CITY OF PORTLAND

BUILDING PERMIT

Located At 15 ALLISON AVE

has permission to build a new single family residence with an attached garage.

1ST FLOOR PLAN
SCALE: 1/4" = 1'-0"

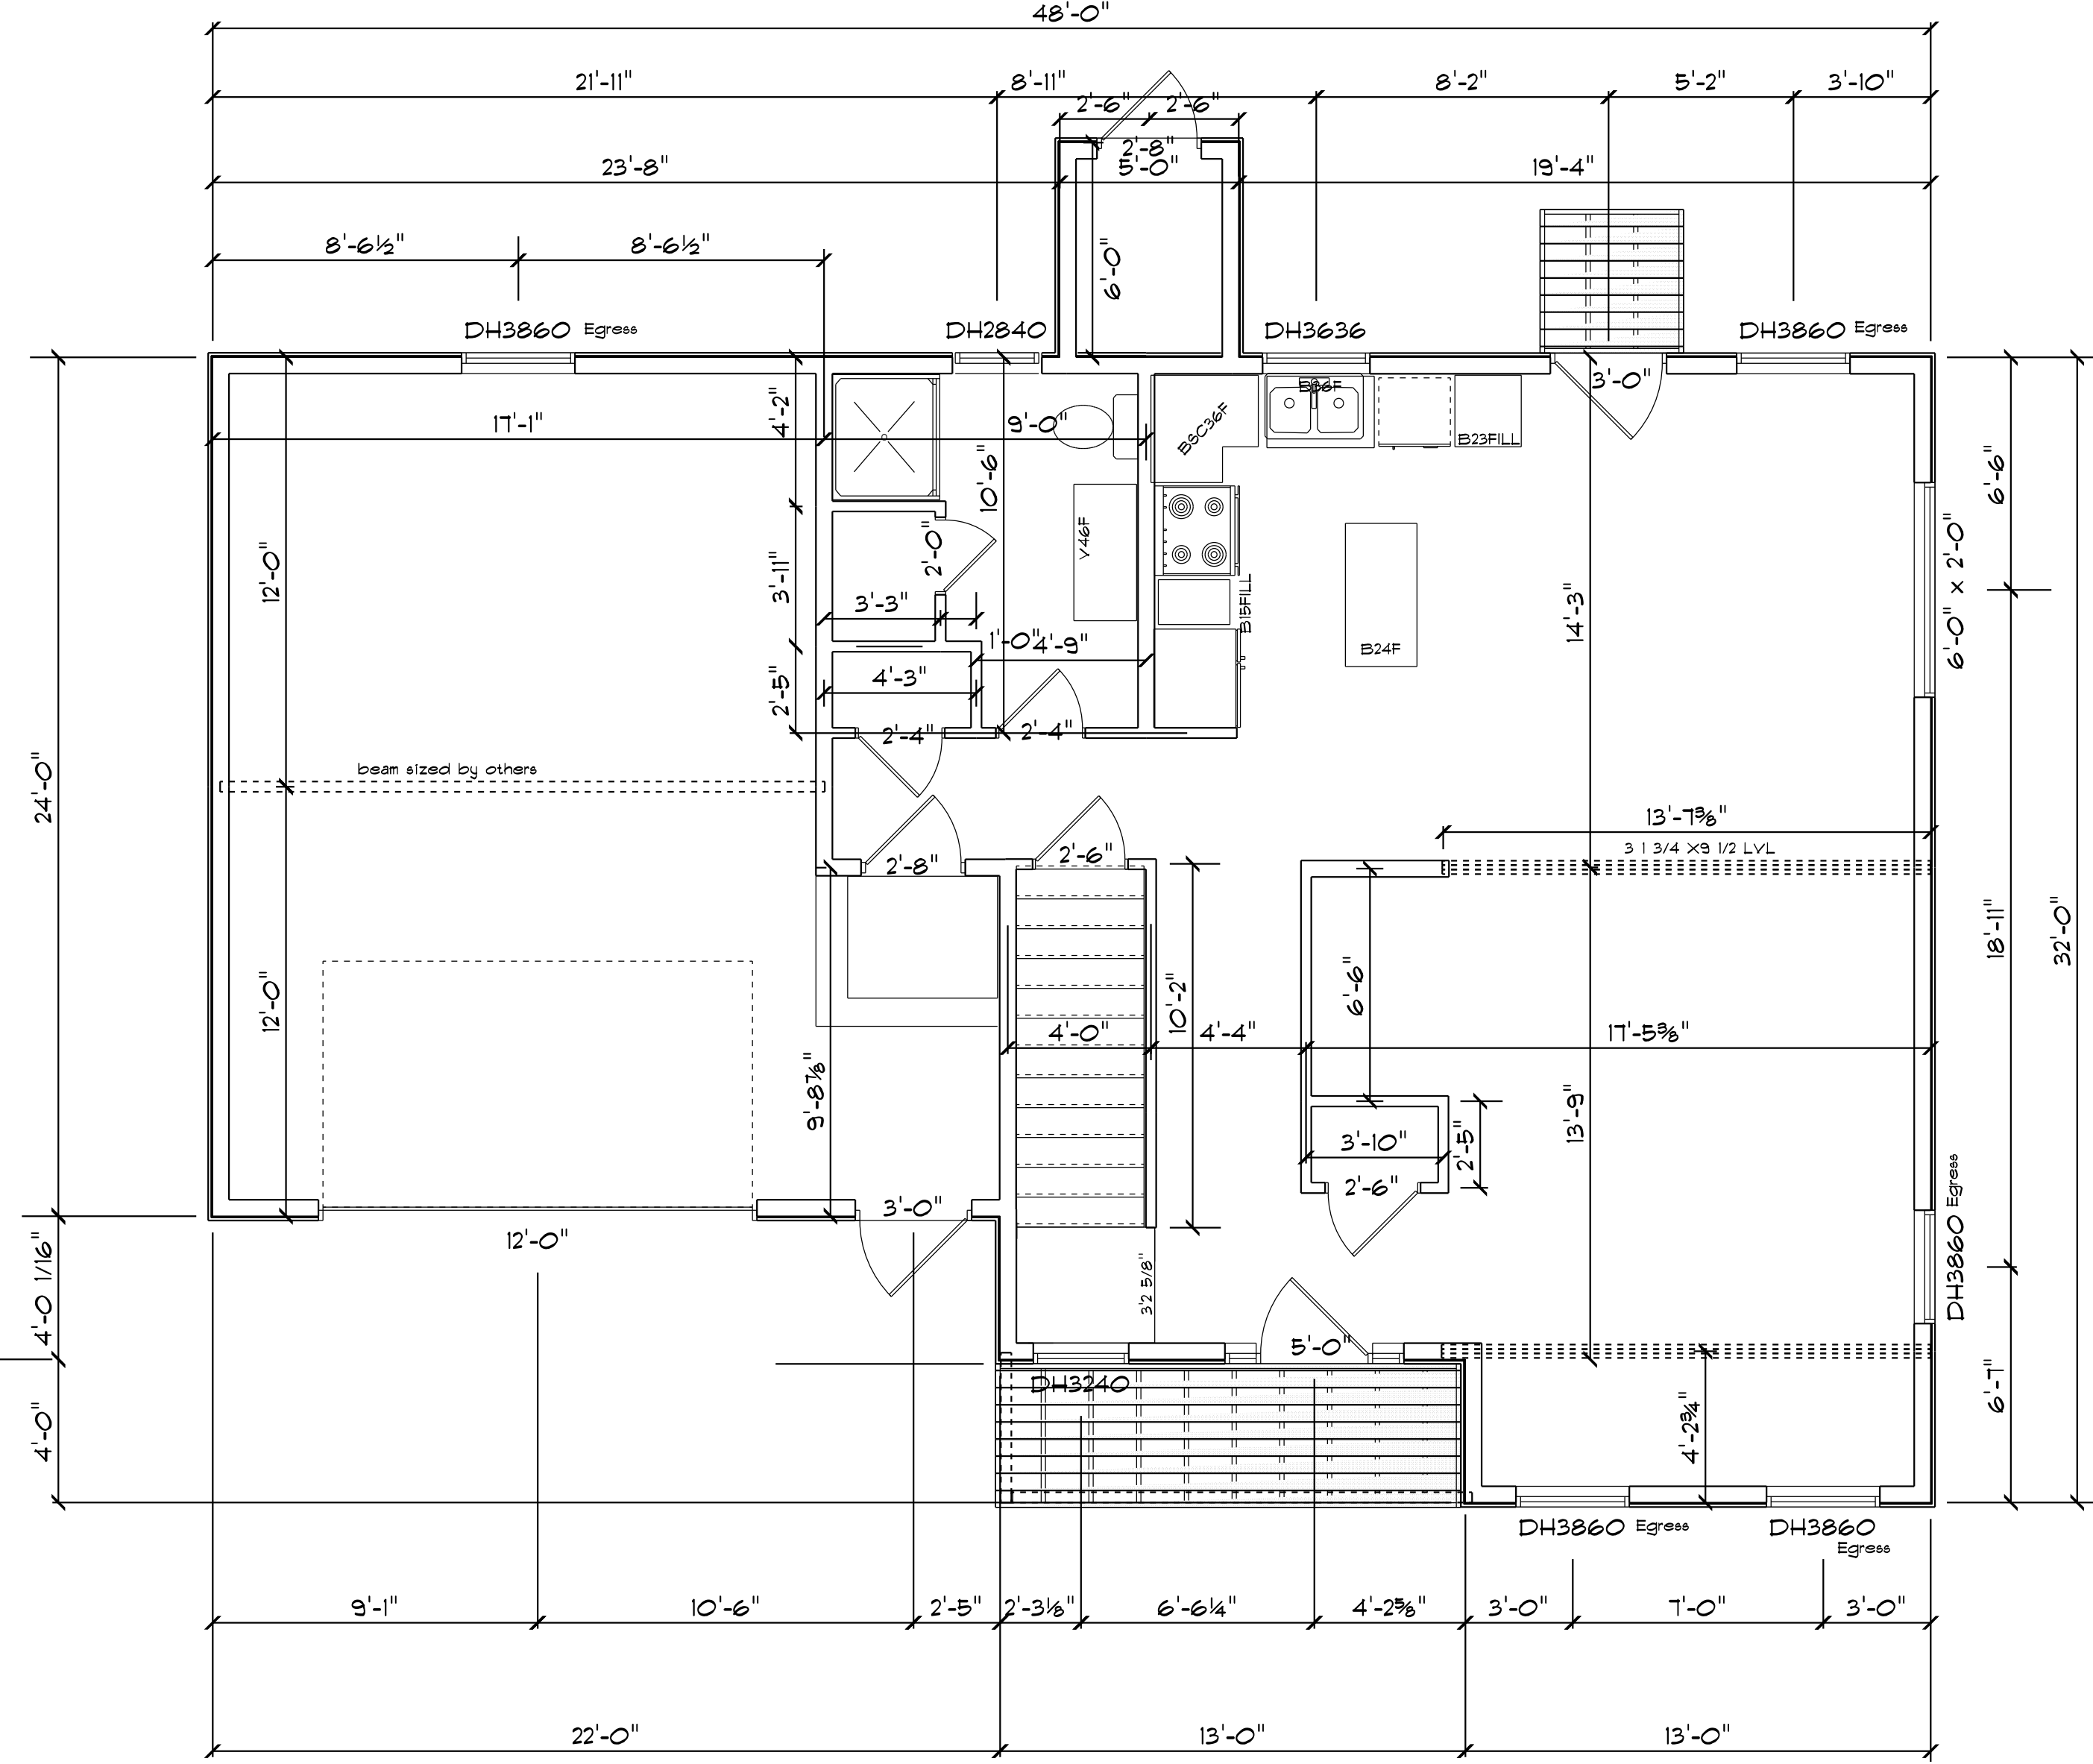
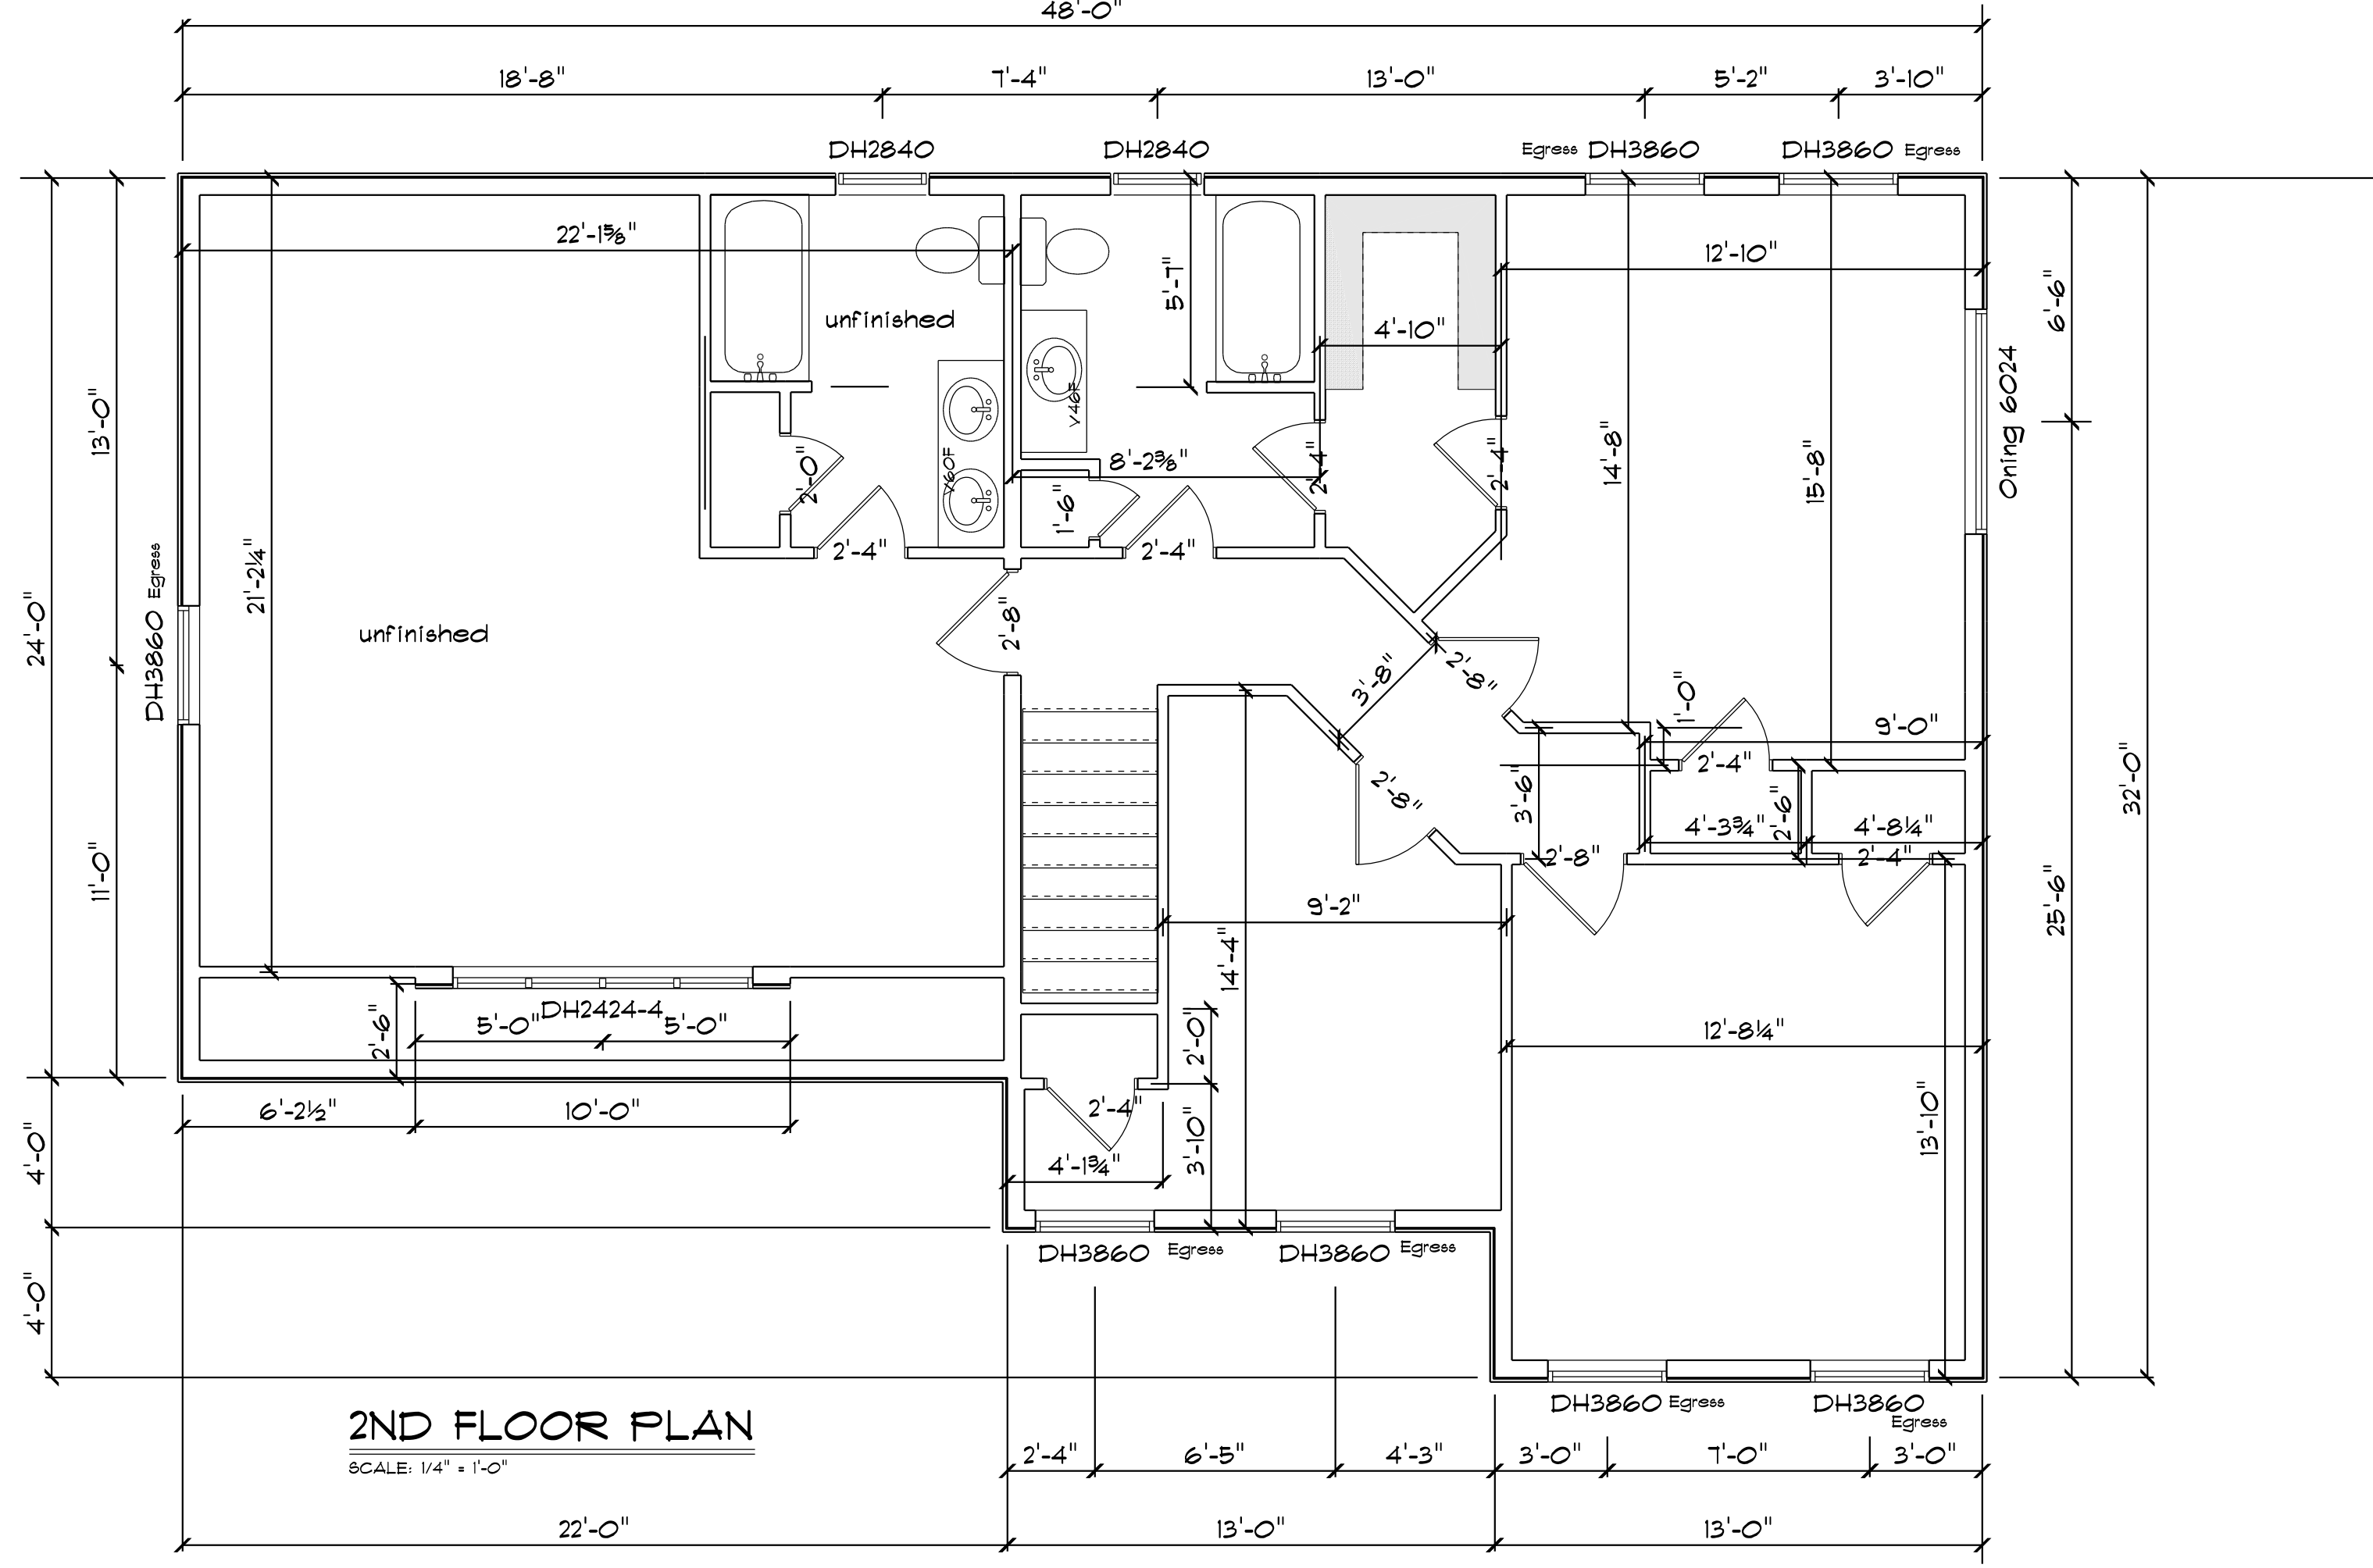
- **Dimensions and Spacing** dimensions are on floor plan. spacing is shown in the cross section
- (Table R502.3.1(1) & Table R502.3.1(2))

Second Floor Joist Species (2 x 10" @ 16 Inches on Center) max span?
